WEST SUSSEX COUNTY COUNCIL CONSULTATION

TO:	Arun District Council FAO: Michael Eastham
FROM:	WSCC - Highway Authority: Tim Townsend
DATE:	2 nd December 2020
LOCATION:	Land South of Ford Lane east of North End Road Yapton Arundel BN18 0DS
SUBJECT:	Y/131/20/DOC Approval of details reserved by condition imposed under ref APP/C3810/W/17/3170059 (Y/80/16/OUT) relating to Condition Nos 7 - means of access/egress onto Ford Lane, 8 - retention & improvement of Public Rights of Way 357, 358, 359 & new cycle & pedestrian routes, 9 - Stage 1 Road Safety Audit, 12 - Travel Plan and 17 - Phase 1 Habitat Survey
DATE OF SITE VISIT:	n/a
RECOMMENDATION:	More Information Required
S106 CONTRIBUTION TOTAL:	n/a

This is the WSCC County Highway Authority (CHA) response to the above planning application for approval of details reserved by condition imposed under ref APP/C3810/W/17/3170059 (Y/80/16/OUT) relating to Condition Nos 7 - means of access/egress onto Ford Lane, 8 - retention & improvement of Public Rights of Way 357, 358, 359 & new cycle & pedestrian routes, 9 - Stage 1 Road Safety Audit, 12 - Travel Plan and 17 - Phase 1 Habitat Survey.

Drawing Title
Sections through public right of way footpath 357

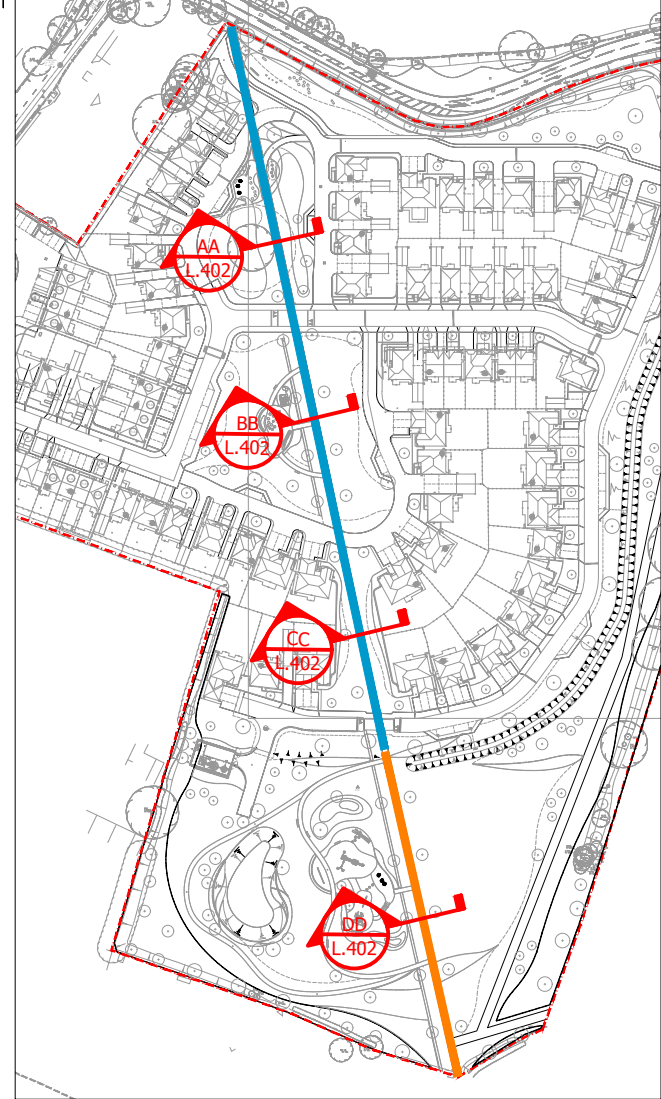
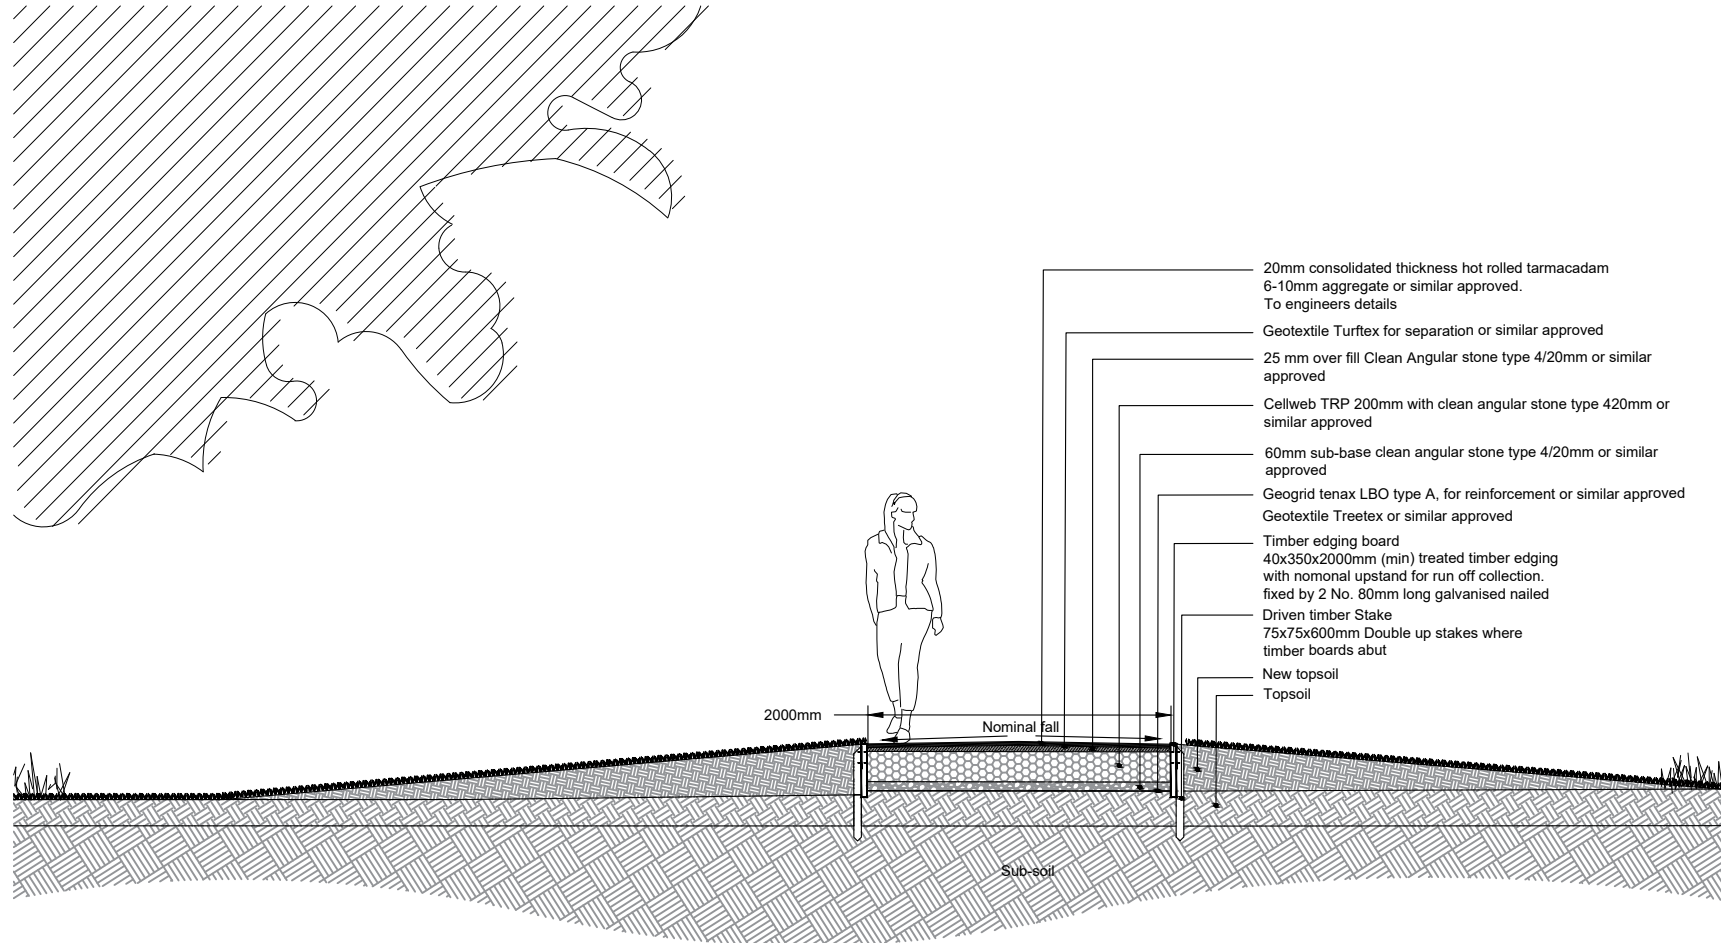
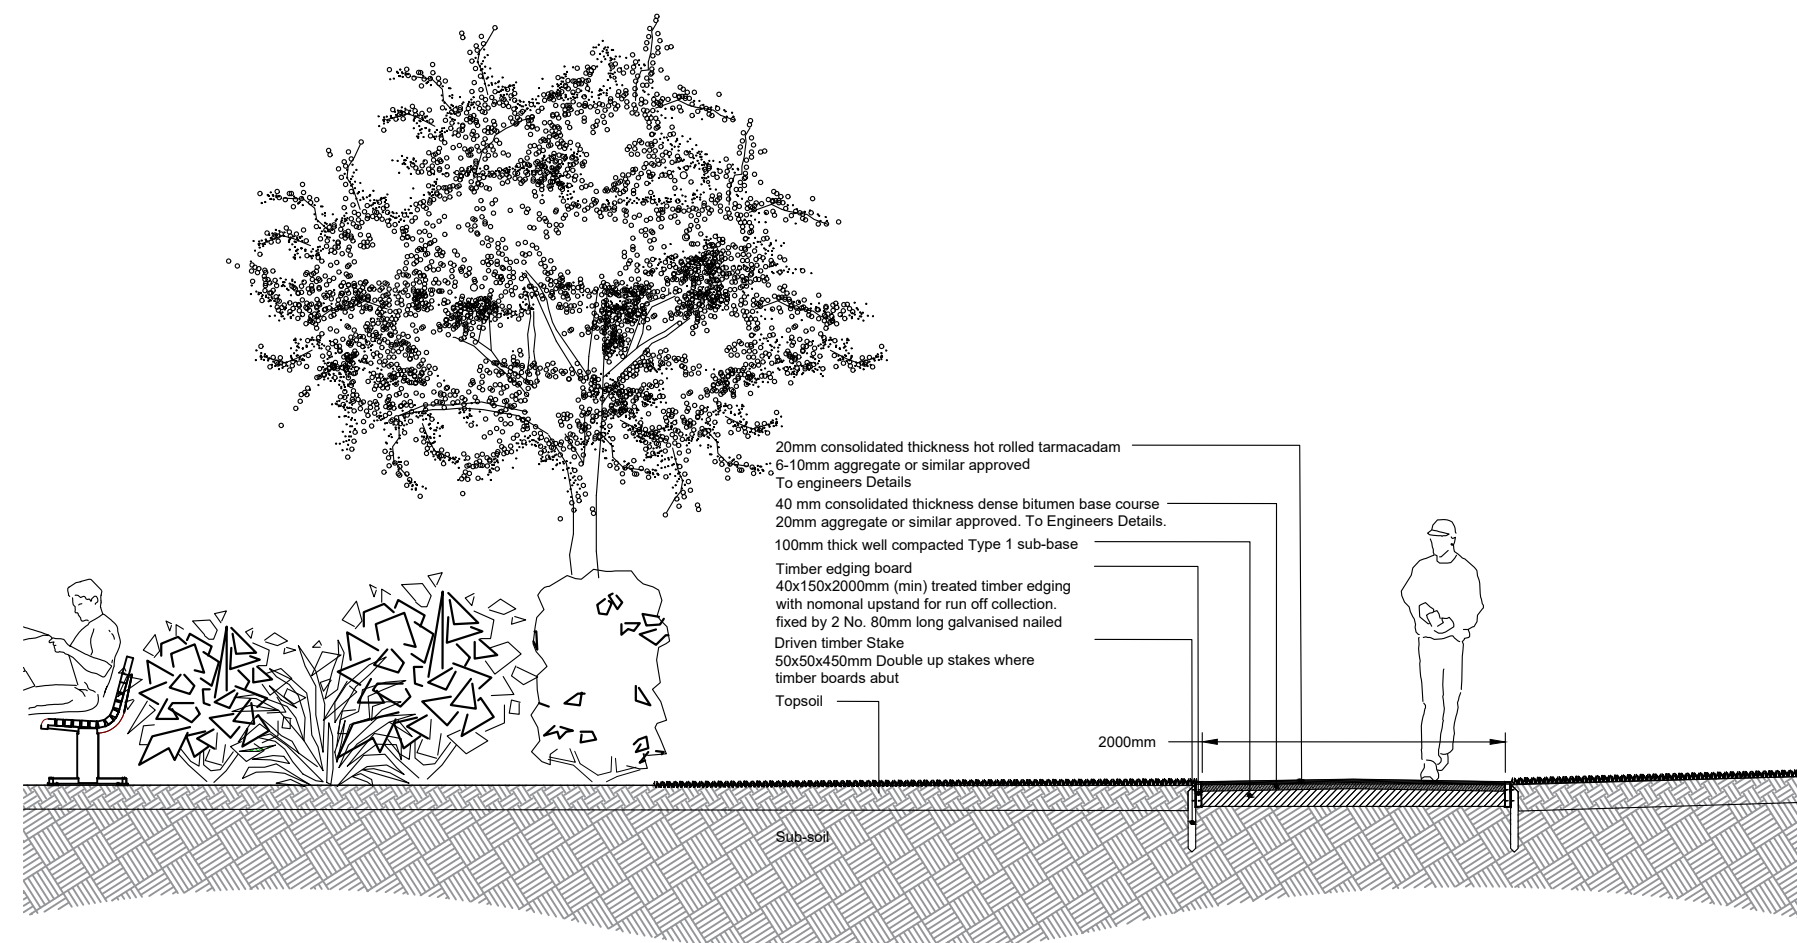
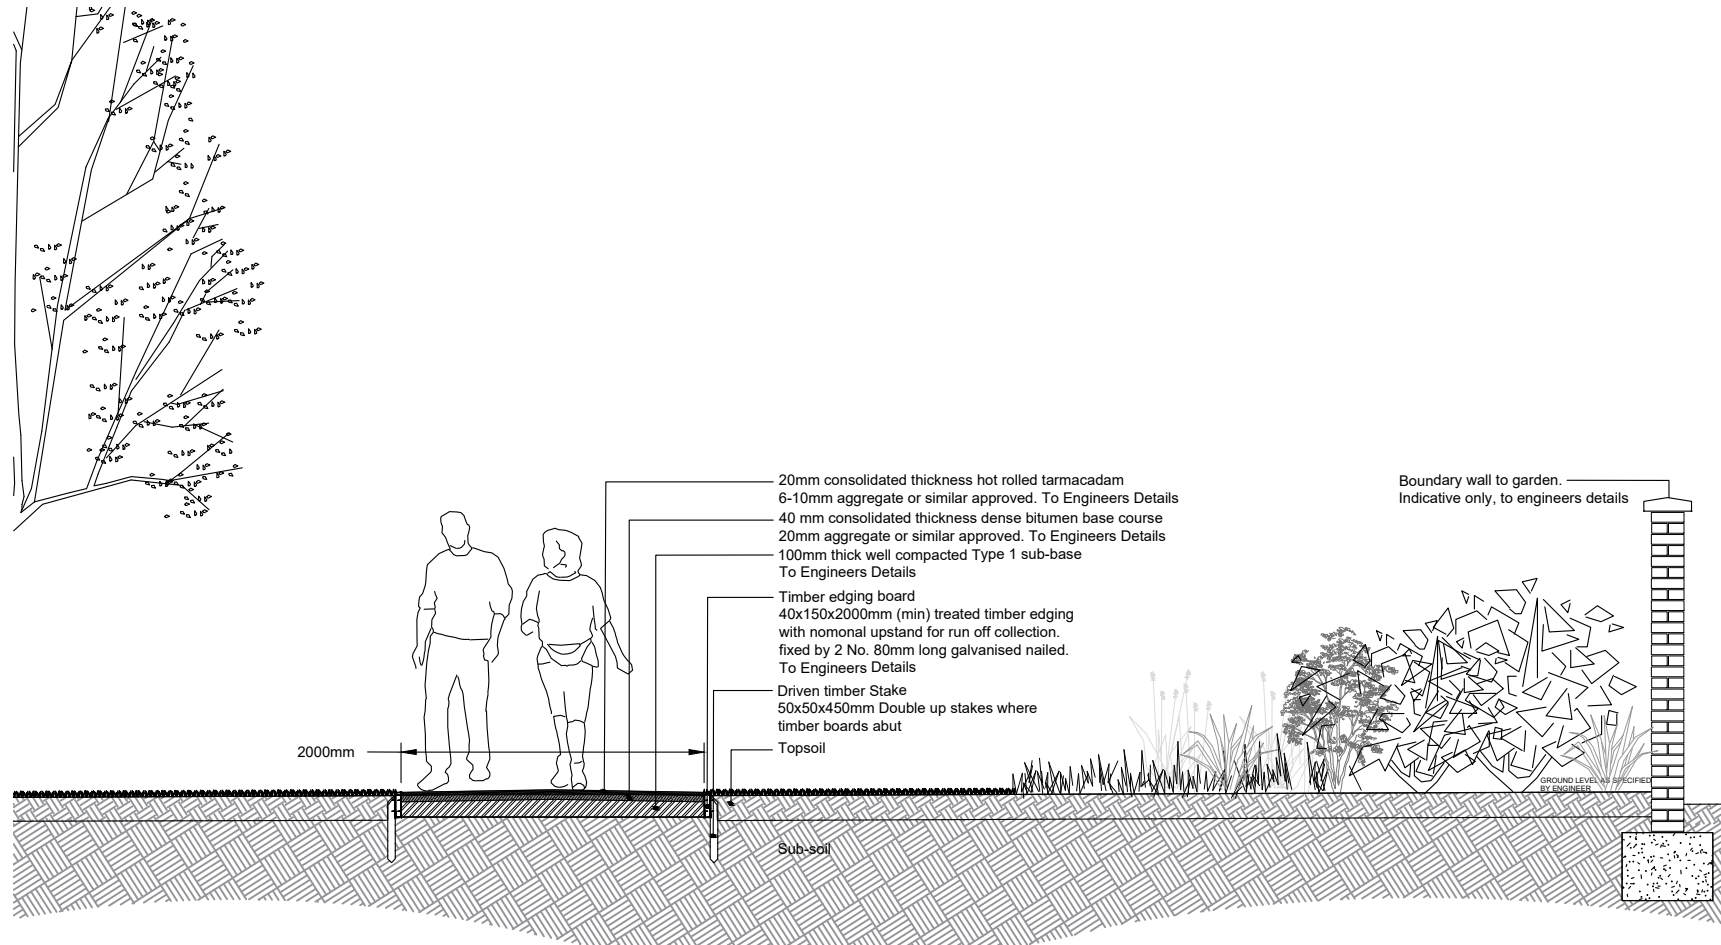
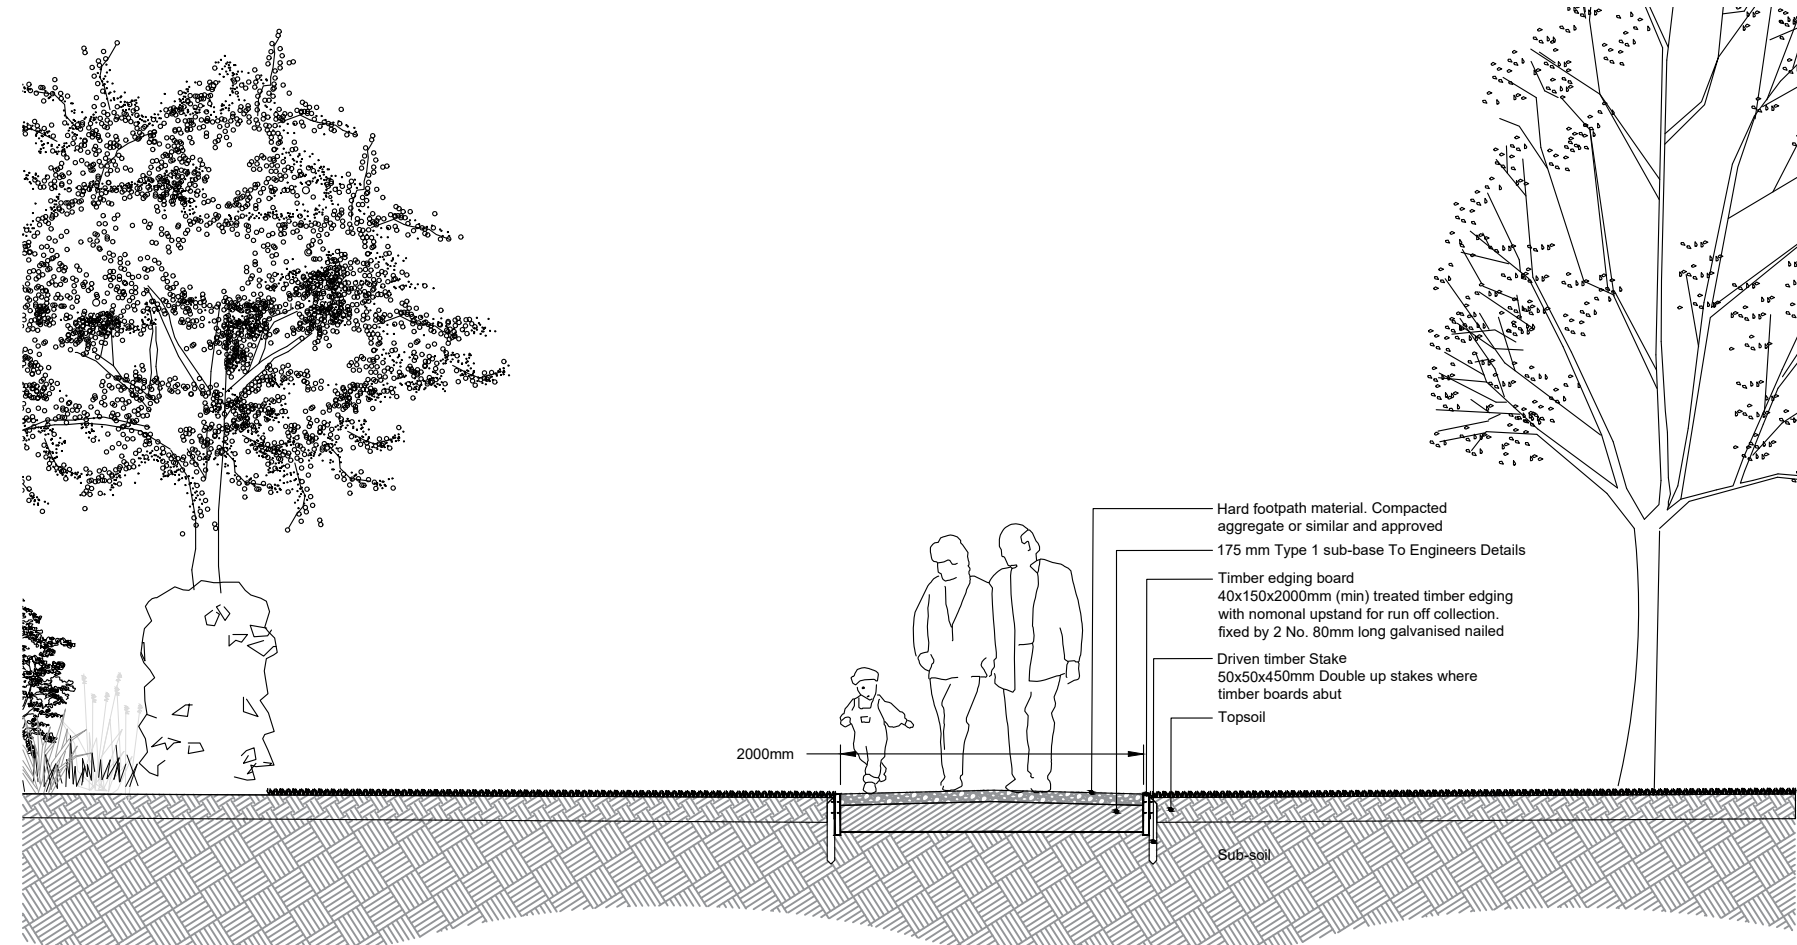
shared foot and cycle use. From observation of the latest drawings, this has not been shown fully as 357 appears to measure 2.0m (it should measure a minimum of 3.0m wide for shared-use), whereas both 358 and 359 are shown measuring 3.0m wide. Since the outline consent, the County Council has been looking at ways to improve access by non-motorised users across the County. This extends to other non-motorised users too and it has been mentioned that access by other users such as equestrians is of interest in the area. Bridleway status for all these paths would legally permit those on foot, cycle and horse to use the paths, albeit recognising that the paths would need to be upgraded, including connections in-and-out of the site. Any path upgrades to permit access over-and-above Public Footpath status would require appropriate Orders to be approved. WSCC PRoW team will be able to advise further.
